Re: Mowbray Road, Lane Cove North, Affordable Housing (SSD-71687208) Request for Additional Information

Table 1: Response to issues raised by DPHI and CPHR Group

Overland Flow Path Sections

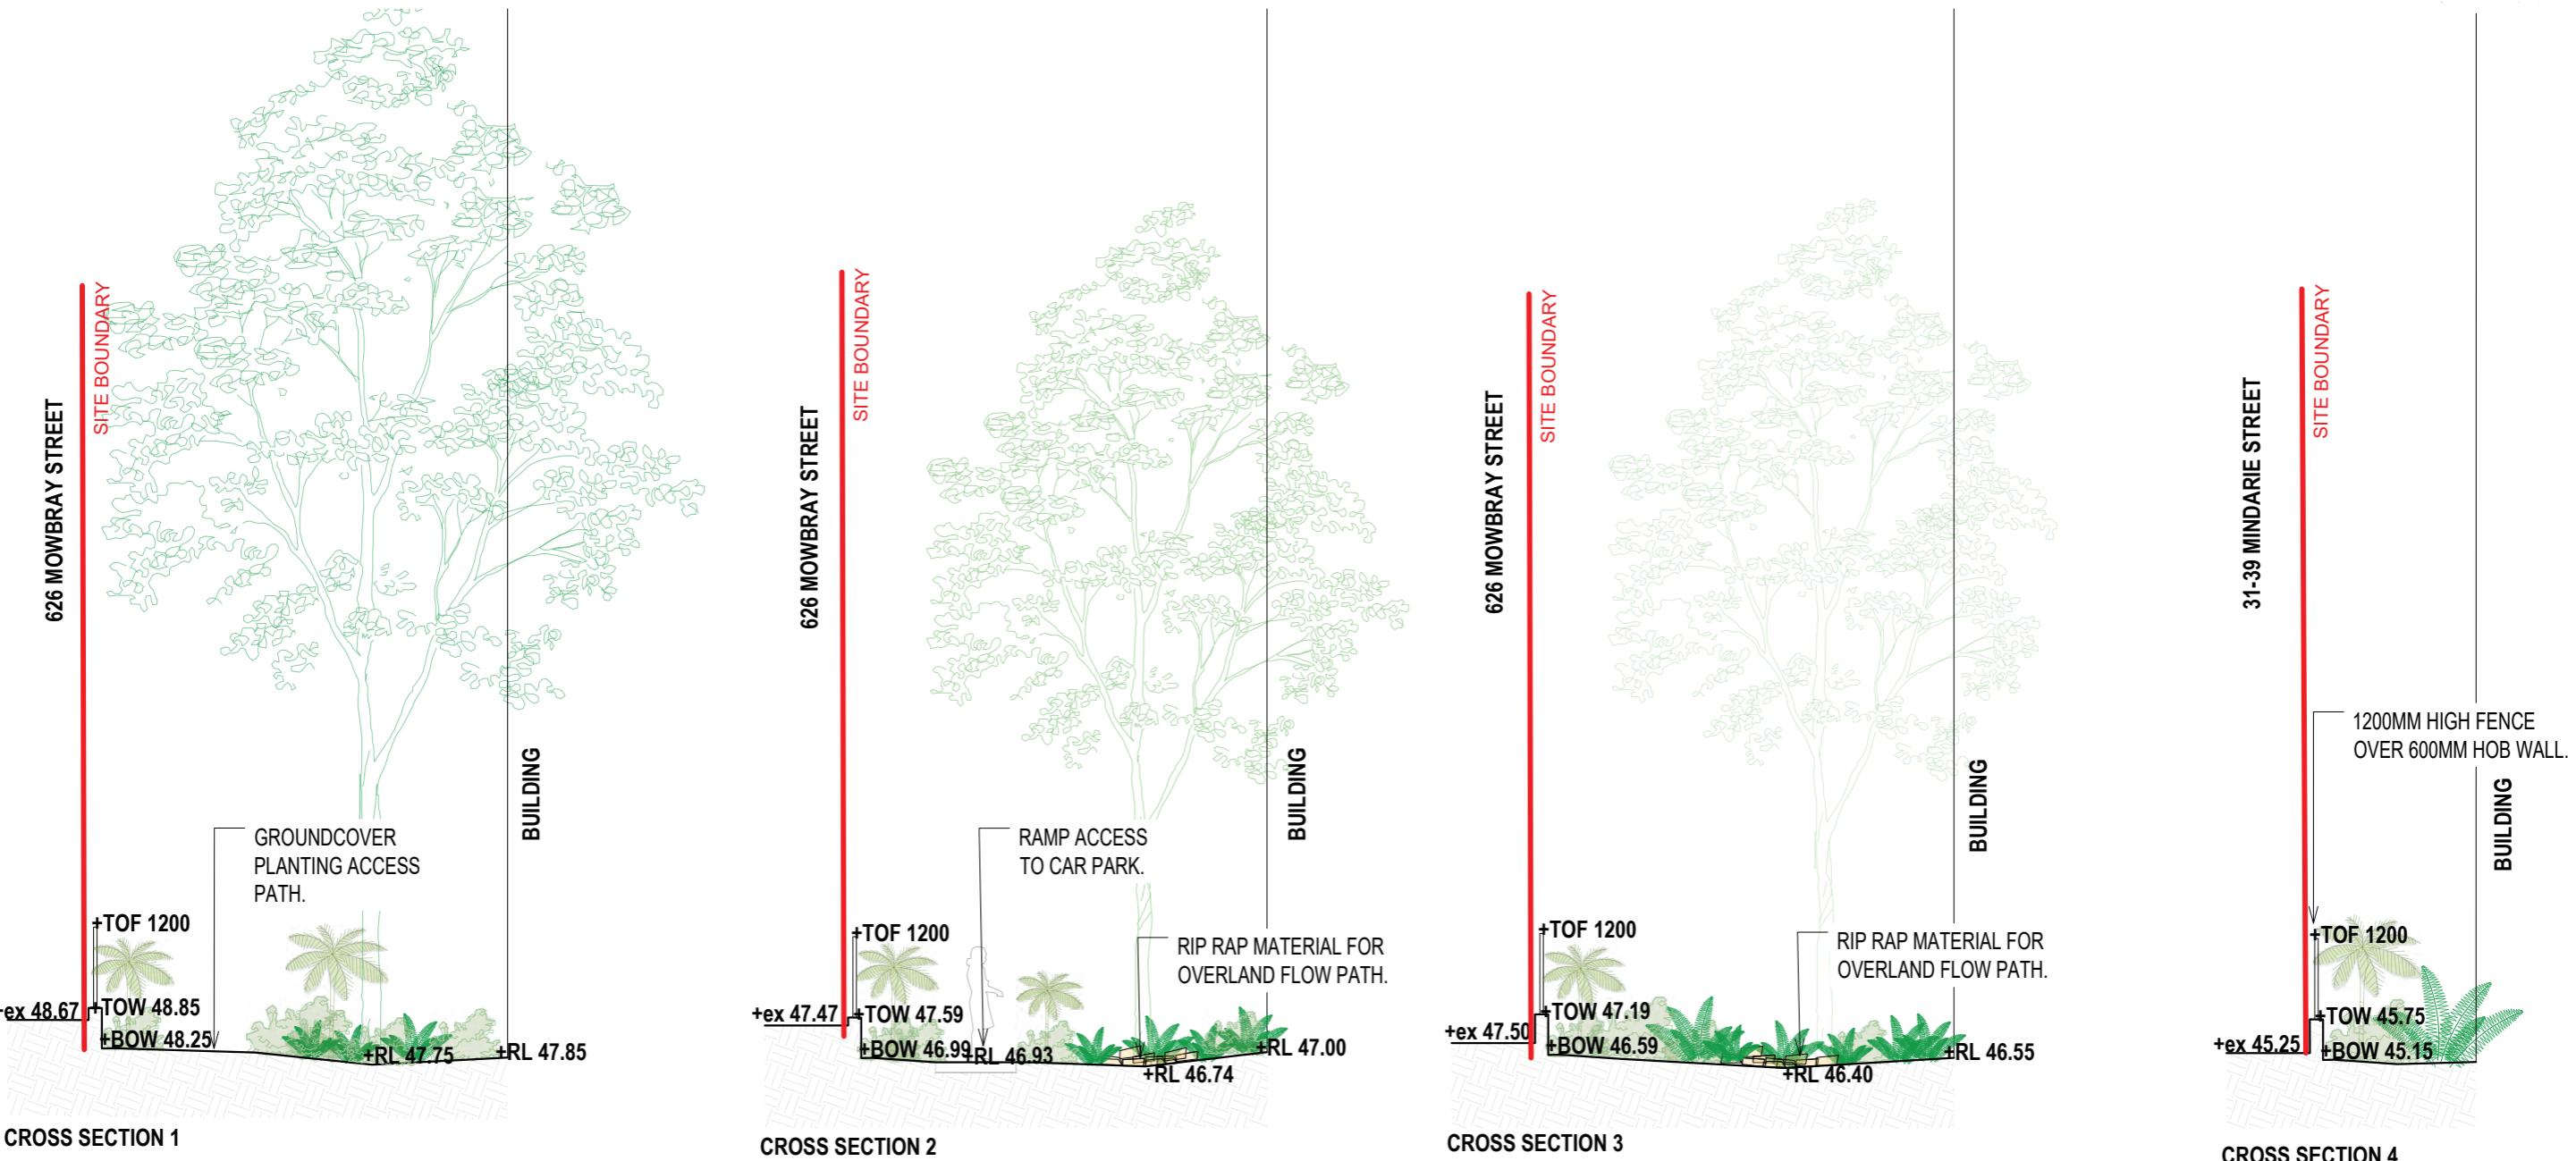
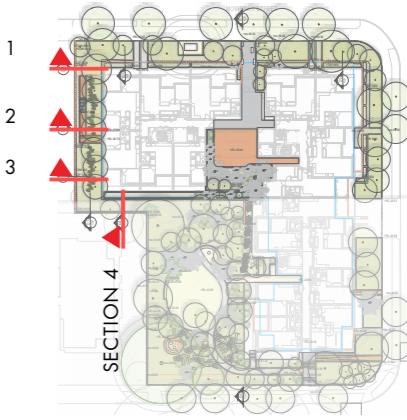
CPHR notes that the landscape plans have been updated to show rip rap to the overland flow path. However, the landscape plans show a landscaped retaining wall across the flow path. The flood mapping appears to demonstrate a continuous gradient in this area and no drop pit has been provided in the stormwater pipeline to indicate a change in level. The RTS notes depths of 0.25 m at 2 m/s will flow in the overland flow path in an event as frequent as the 5% event which would be considered H5 hazard. This is not consistent with the provided flood mapping.

- Check the FIRA and landscape plans for consistency and provide results in a manner which clearly describes expected flood behaviour and how this risk is managed.
- Prepare landscape cross sections and long sections for the constrained overland flow path down the side of the building which can be modelled in the FIRA. This is requested to ensure that the same design criteria are applied to flood modelling, stormwater design and landscape/architectural design.

This issue is addressed in the updated Flood Stormwater Management and Flood Impact and Risk Assessment at Attachment A and DPHI and CPHR RtS Response Letter at Attachment B.
